About the application

Application number: 2020/90667	
What is the application for?:	Formation of entrance porch and outdoor terrace, internal refurbishment, replace
Address of the site or building:	Farmers Boy Inn, 44, Marsh Lane, Shepley, Huddersfield, HD8 8AP
Postcode:	EH12 9JZ

client					
STAR PUBS AND BARS					
address					
THE FARMERS BOY 44 Marsh Ln Shepley Huddersfield HD8 8AP					
drawing title					
PROPOSED GROUND FLOOR PLAN					
drawing no	rev	date	drawn by	checked	scale @ A1
7724-02	a	21.05.18	LB		1:50

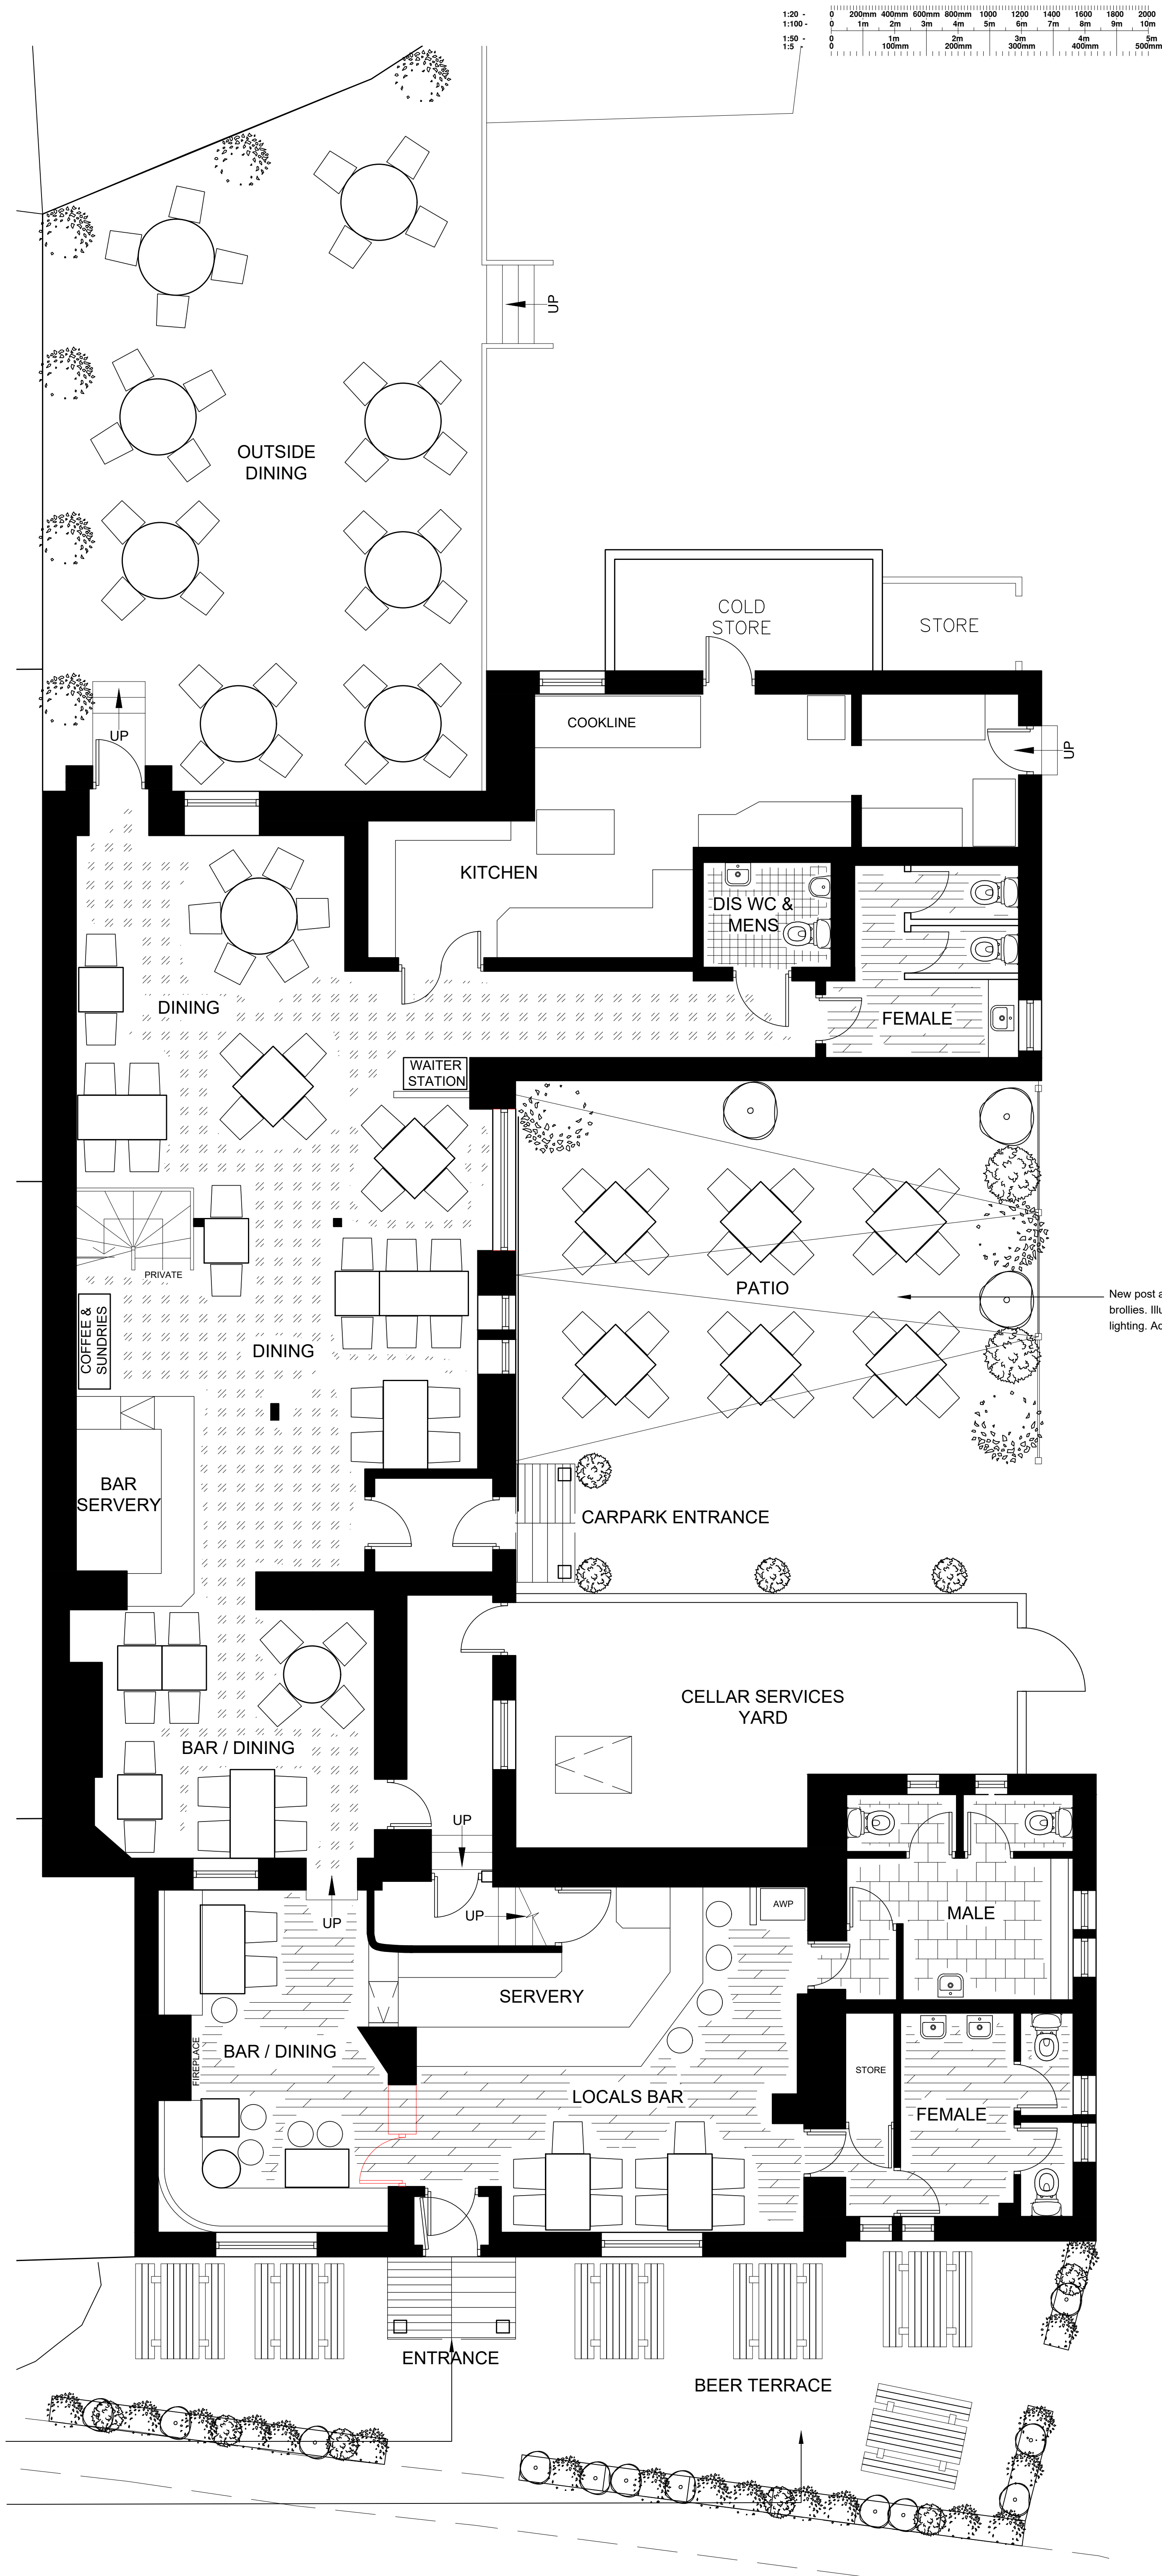
Type of comment: A general comment
Whilst I fully support the efforts to get this public house back in business I have misgivings about the proposed porch. As a sometime patron of the Farmer's Boy when it was still open I recognise that the front door is susceptible to the wind and rain. However the proposed porch, being of openwork design does little to alleviate this. More particularly the design is totally out of keeping with the local vernacular and seems to be an attempt to be trendy. It ends up looking rather "twee" and would in my view be a waste of good timber. It is interesting that one of your own officers has also expressed reservations about the proposed design. I could (just) live with a porch built in stone to match the existing with a door positioned to the leeward side of the prevailing wind ie: facing down Marsh Lane. Better however to leave as is.
